From: Iain Osenton
Sent: 19 October 2023 12:11
To: Suzanne Taylor
Cc: dcregistration; Planning
Subject: 23/00170/REM CDC Arboriculture

From desk based assessment.
Comment – No objections.

Tree Retention and Removal Plan

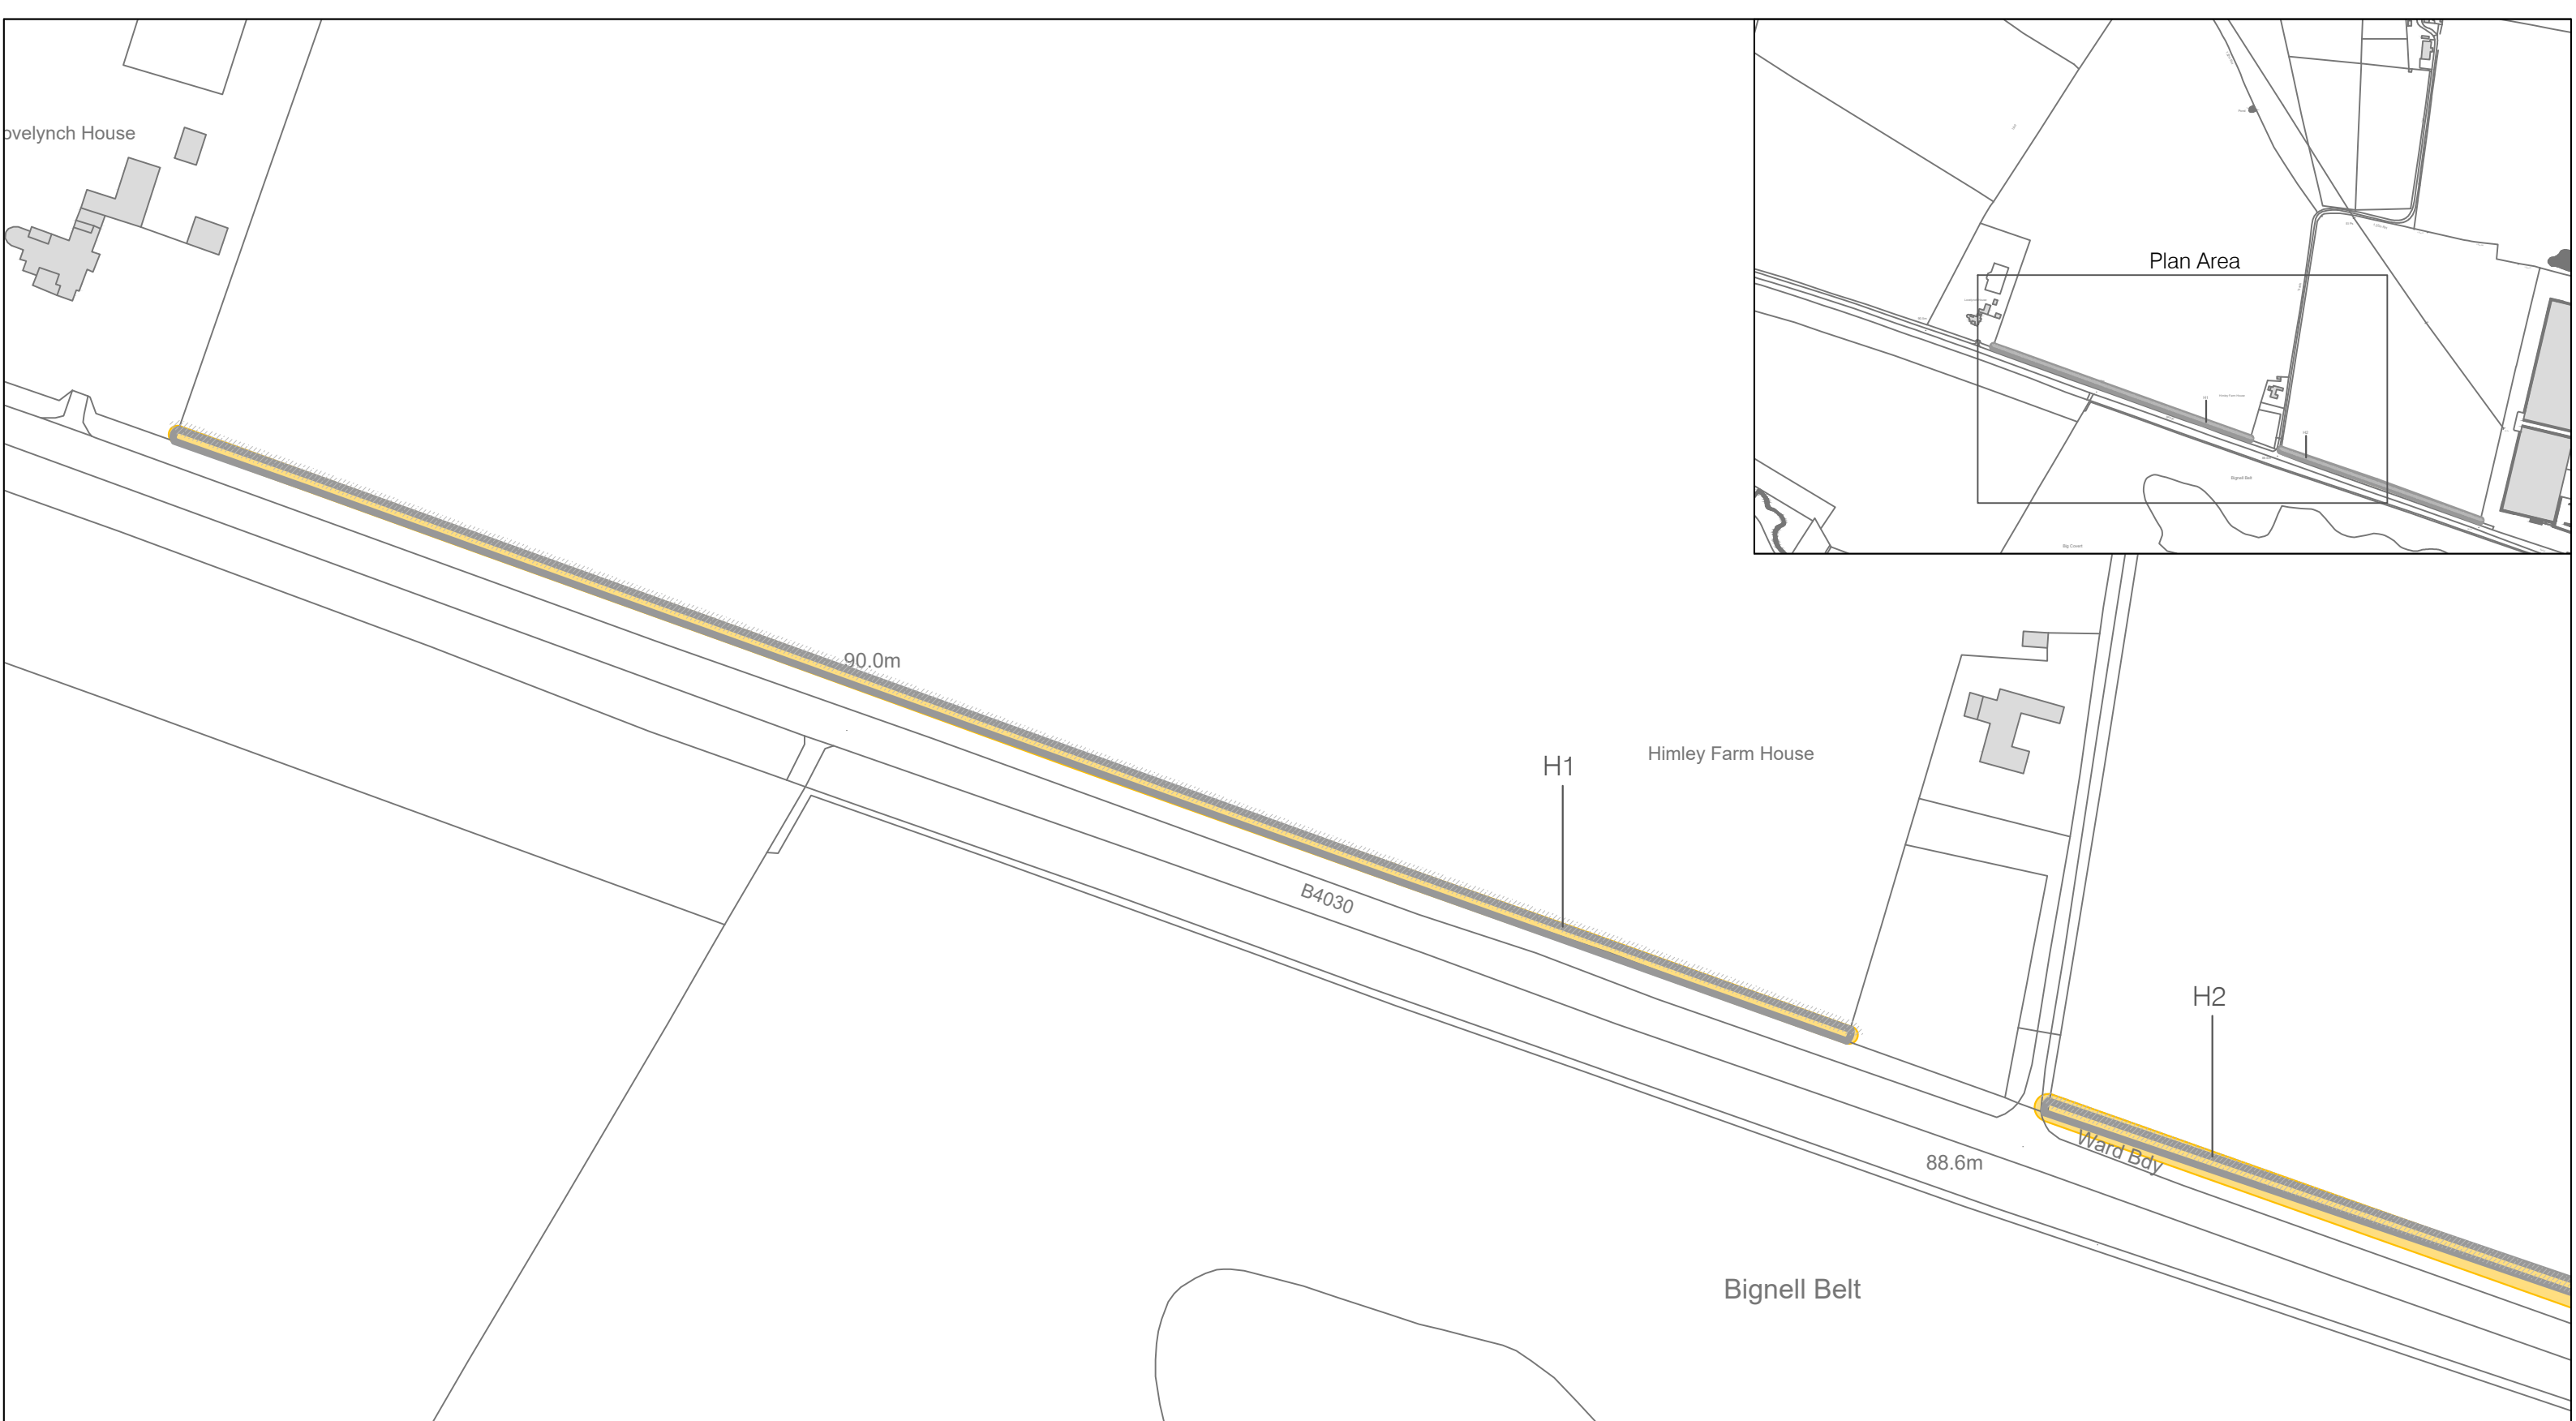
The proposal requires removal of x2 30m sections of BS5837:2012 category C hedgerow. Category C under BS5837 is not considered a major constraint to development, I'd request though this is considered alongside any further removals in order to condition appropriate replacement planning or mitigation for the removals by way of hedge improvement elsewhere within the site.
